From: David Fuller [REDACTED]
Sent: 22 May 2019 10:45
To: Zac Denton
Cc: Laura Gibbons; [REDACTED] Robert Clark
Subject: Re: Apple Barn Cottage - CM/5/19/HH

Subject: Apple Barn Cottage - CM/5/19/HH

Please find attached the surface water drainage design based on infiltration testing as previously discussed.

Project			
Apple Barn Cottage			
A259			
Climping			
Client			
Alex Stephens			
Drawing Title			
Surface Water Drainage			
© This drawing is copyright. It may not be copied or reproduced without written authority.			
Scale	As shown	At original	A3
Drawing Number	2017/SK4	Revision	-

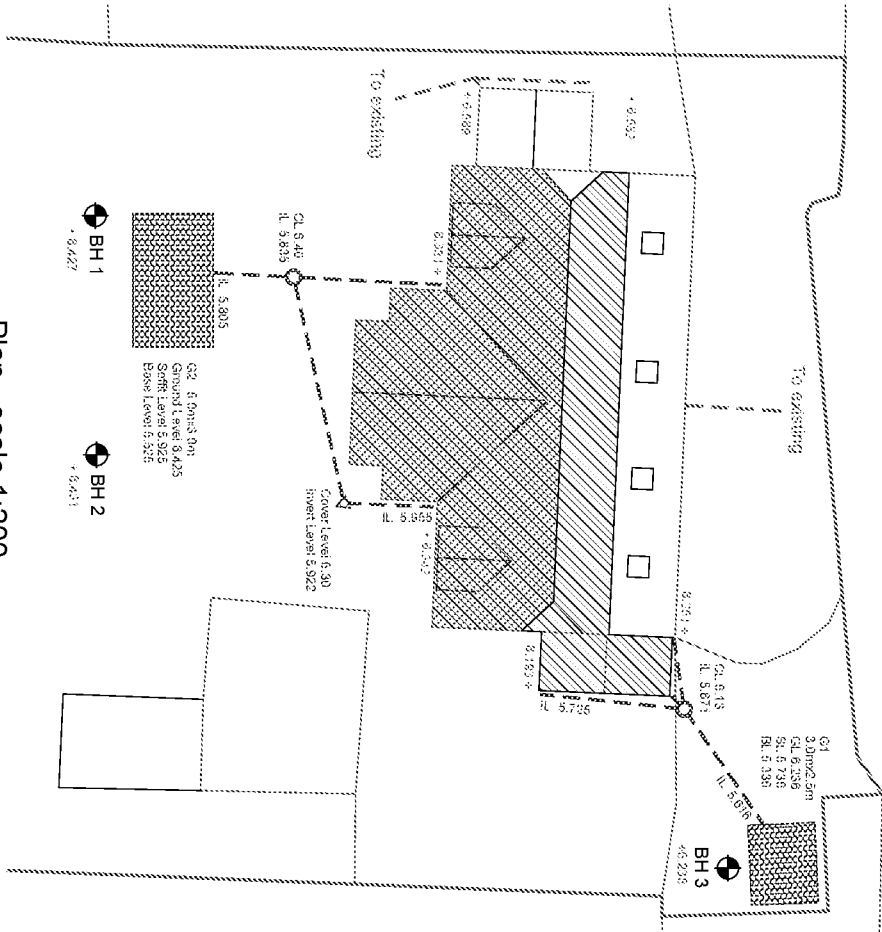
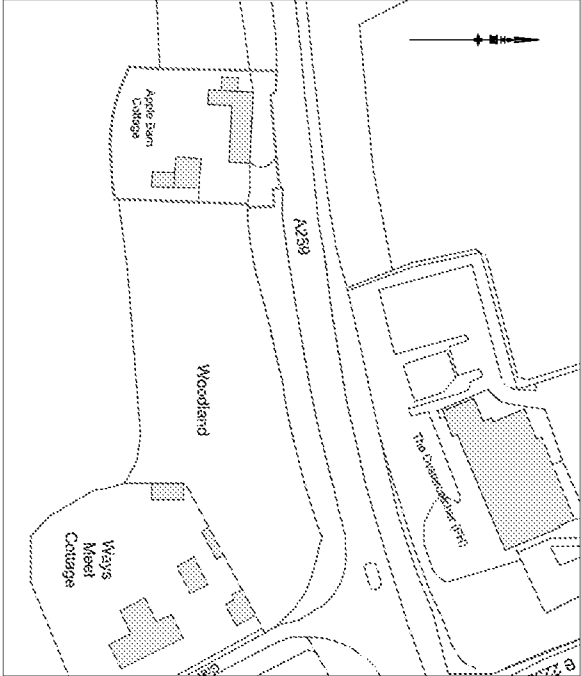
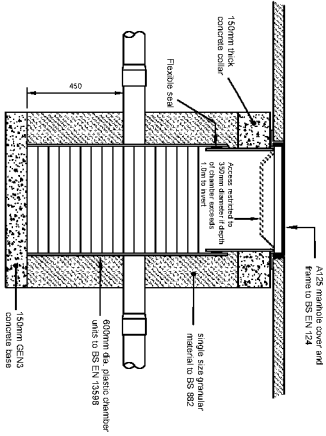
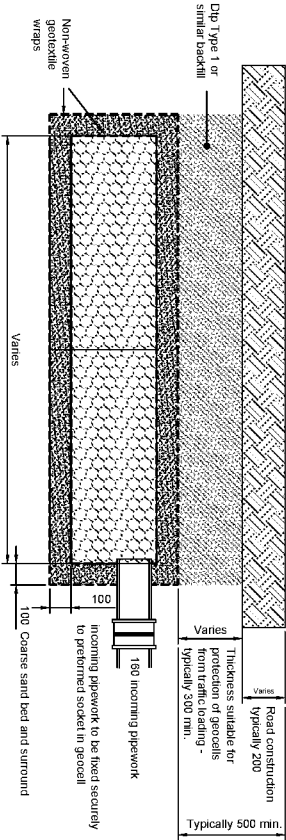
Further information has been provided about the depth of infiltration tests and the rates at each testing location. I would like to see the test result from BH3 used in design of G1 soakaway. And the infiltration rate of BH2 at 929mm depth used in the design of G2 soakaway. These results are those that most accurately reflect the location and depth of the proposed soakaways."

Please can we get the surface water drainage calculations supplied to support the proposed design.

Please can the applicant also submit further details of the infiltration testing. I note that the layout states that an average rate has been used in design. Please can the depths of infiltration testing and results be supplied to ensure that the infiltration rate used in design is appropriate.
